Planning Application – Alloways, 33 Shelley Road, Bognor Regis, PO21 2SN – Planning Reference BR/76/19/PL

I would like to object to the planning application for 33 Shelley Road on the following grounds:

Proposed Conversion Proposed Plans Planning
Date March 2019
Scale 1:50

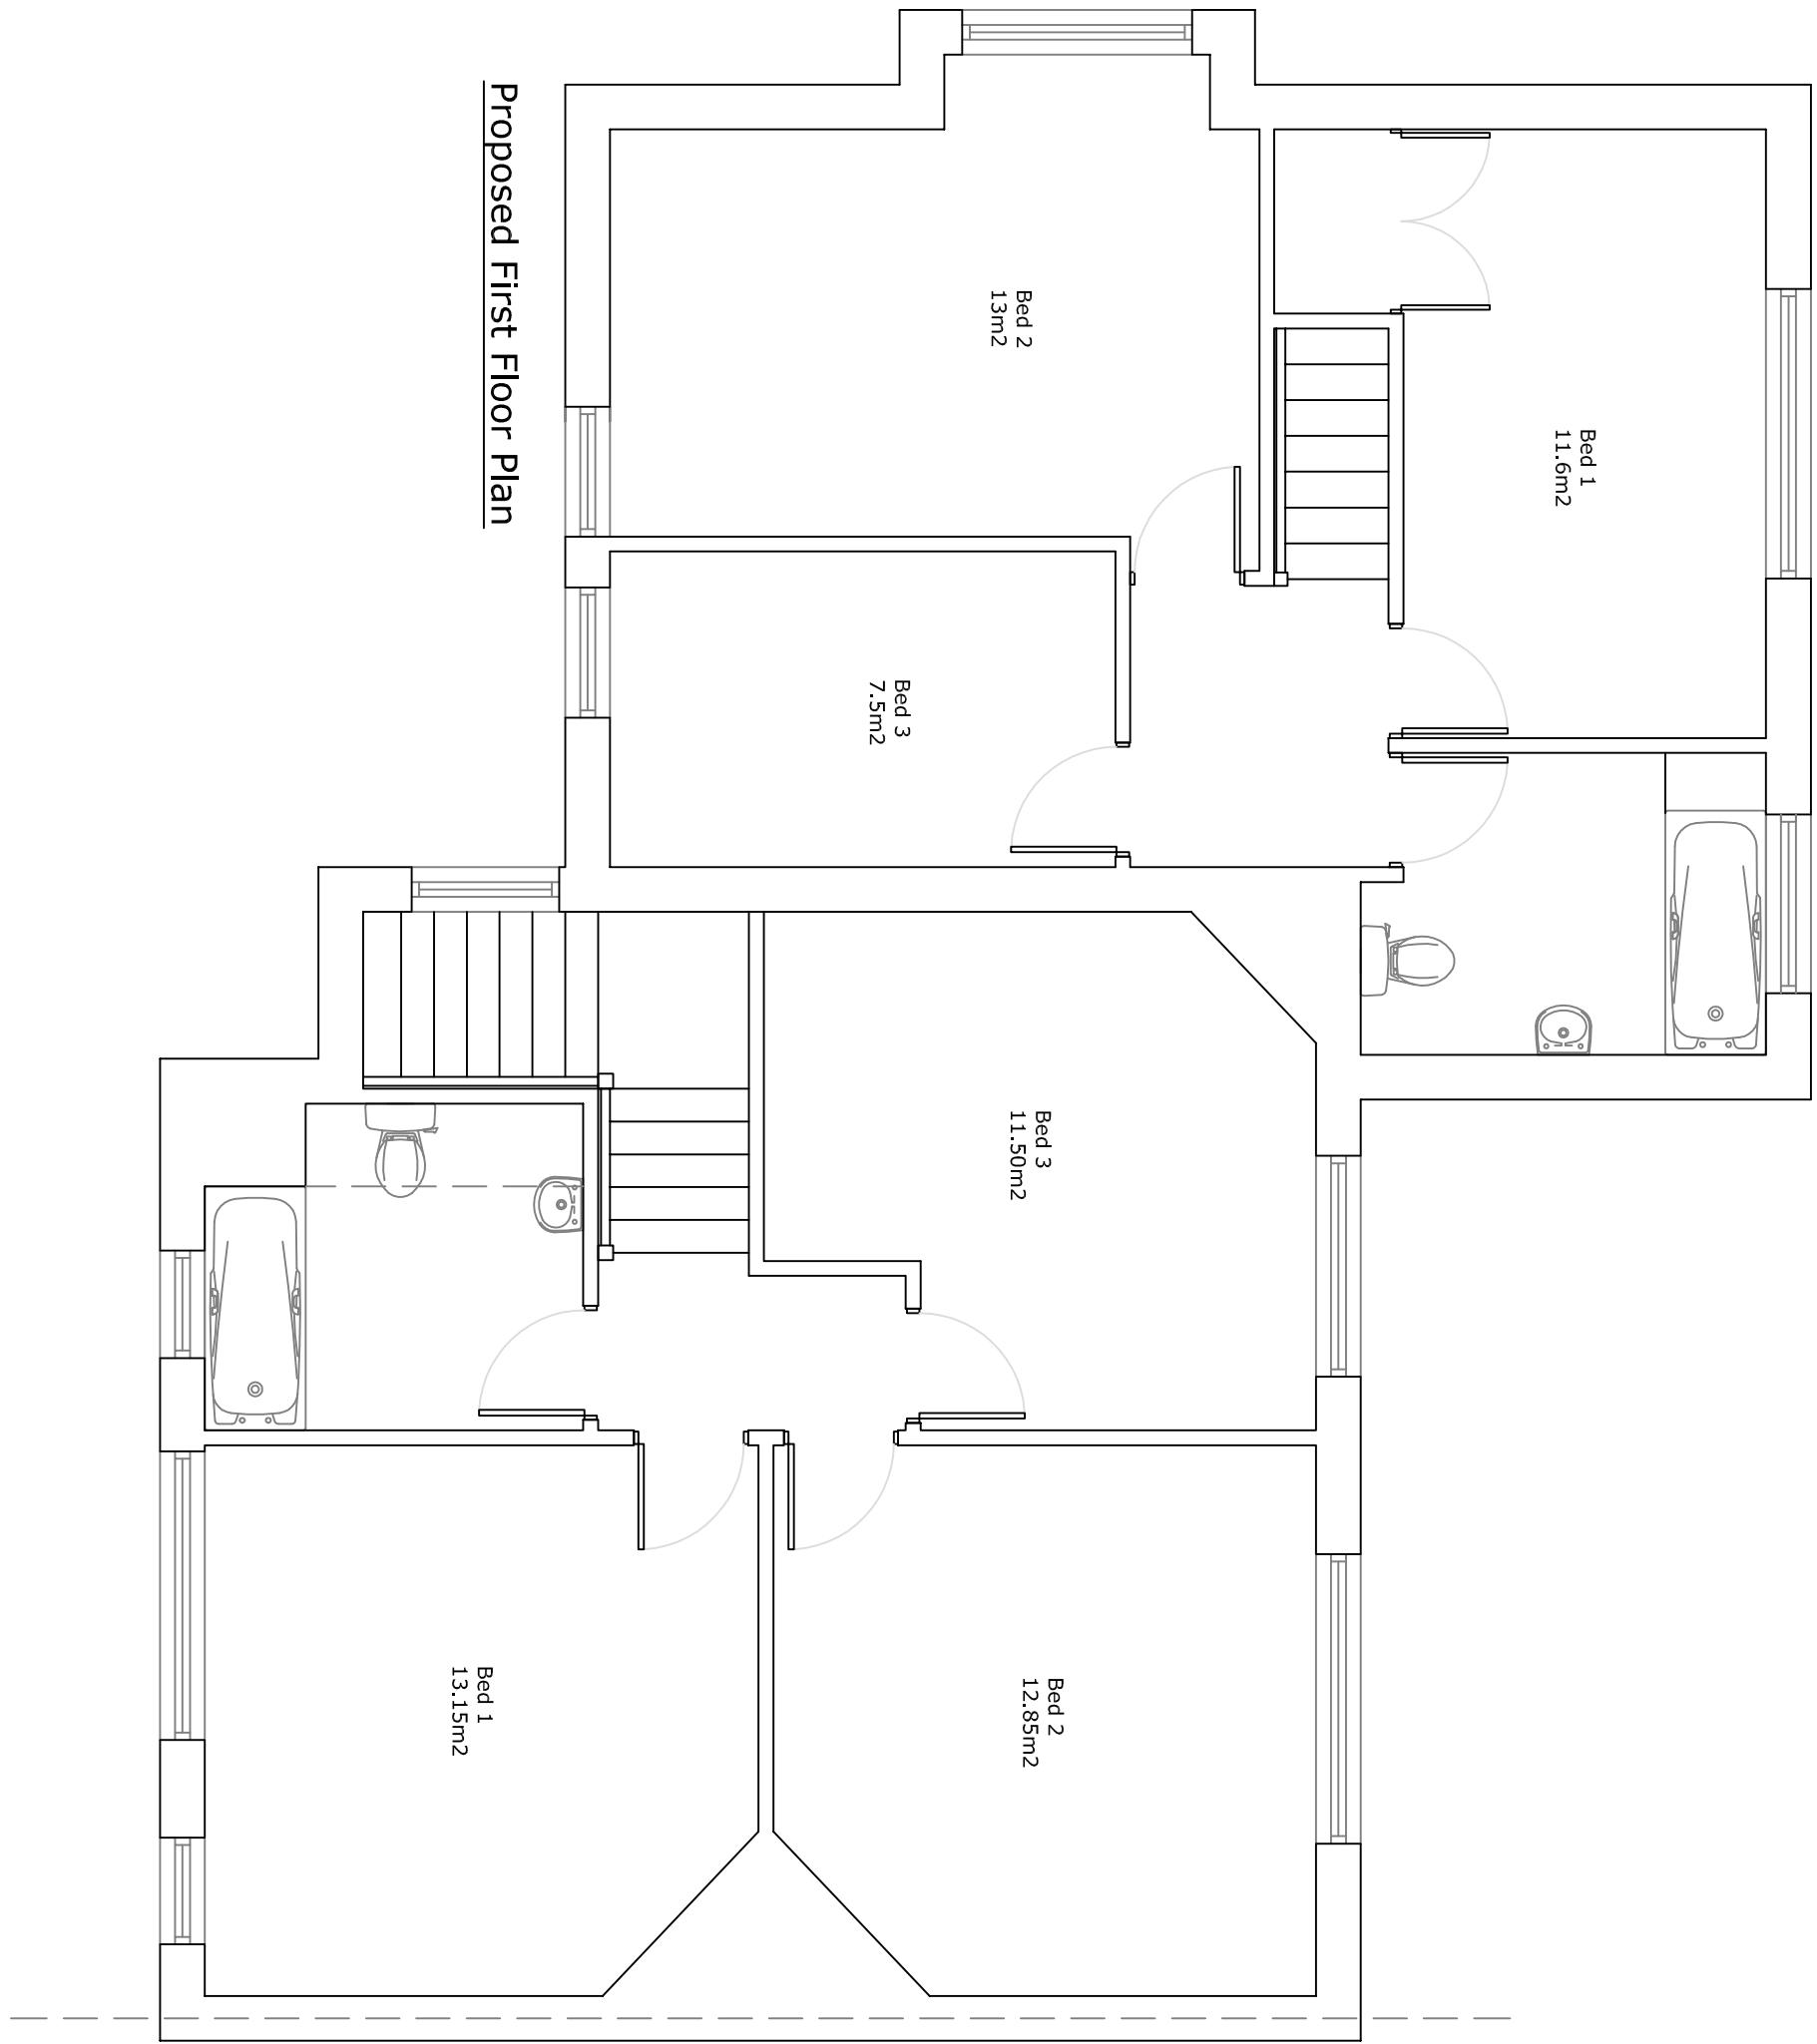
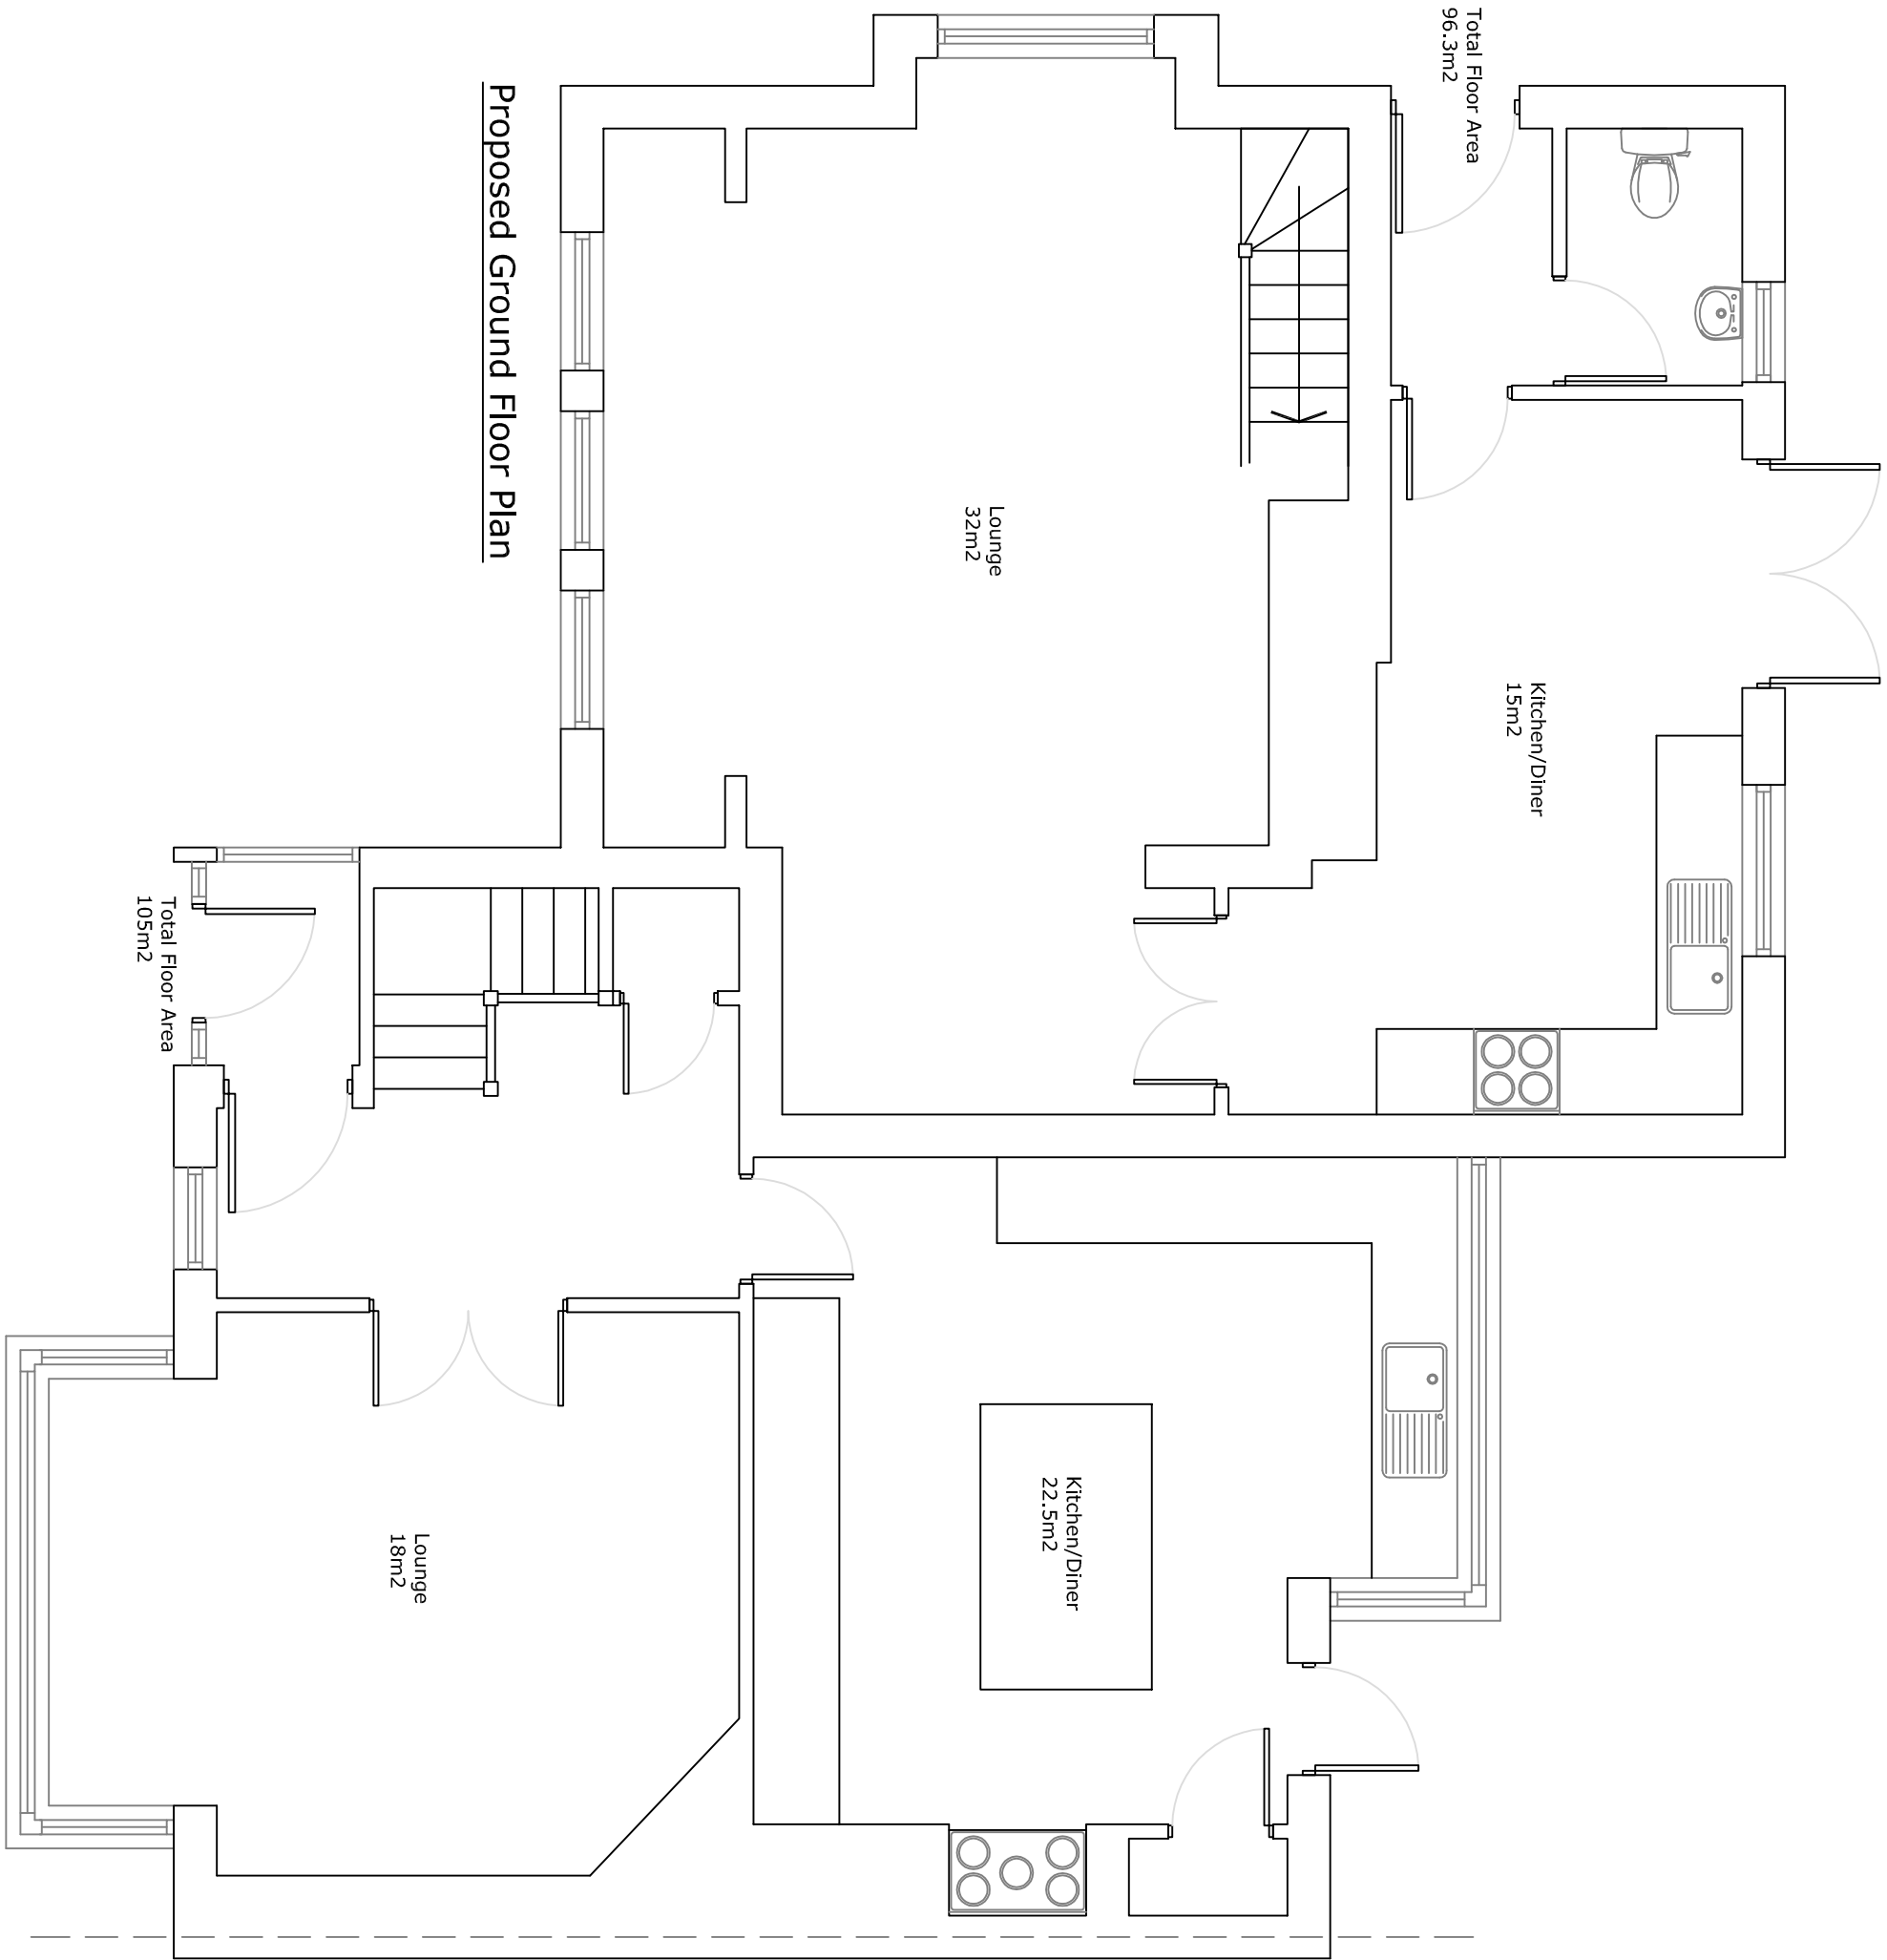
- 3) The erection of a two storey extension will reduce the amount of light that is enjoyed by the houses on either side (31 and 35). We do have right to light and not to have this reduced by the erection of an extension.
